Harnett County Government Complex  
307 Cornelius Harnett Boulevard  
Lillington, NC 27546

June 2, 2005

Re: Status of Improvement Permit Application #05-5-12219

Lot 15 - Prairie Lane, Broadway, NC
Fox Run Sub-division

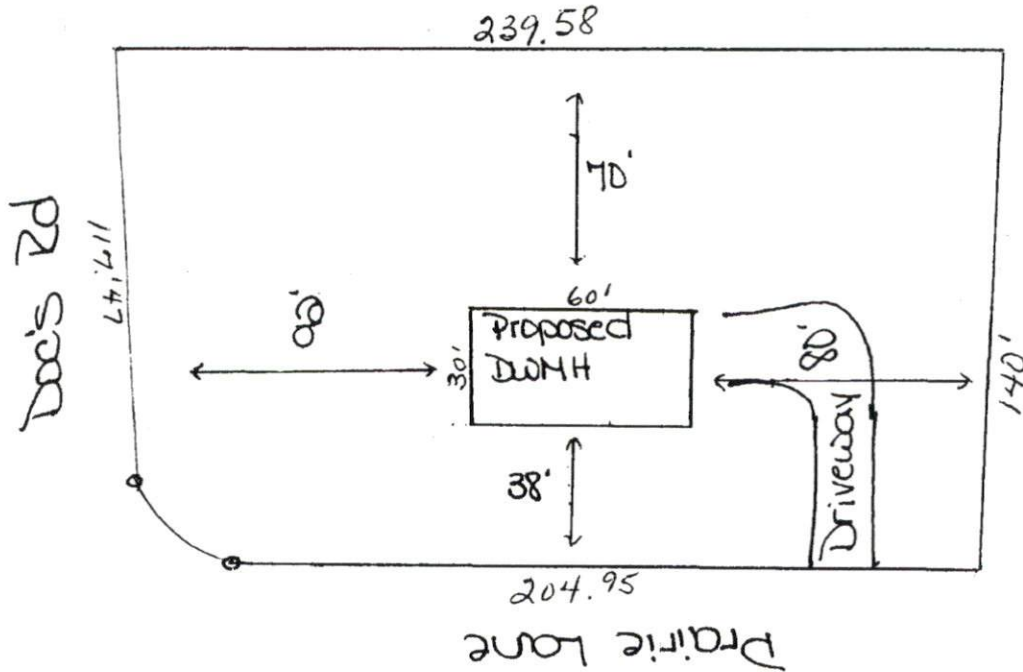
- 1. Property lines/corners not marked or labeled
- 2. House corners not marked or labeled
- 3. Directions not clear to property
- 4. Property needs brush or vegetation removed
- 5. Backhoe pits required
- 6. Other You will need to move the house so it will meet the following set backs – see attached map- Resubmit new plot plan to Central Permitting's office and reconfirm through the automated phone system (IVR).
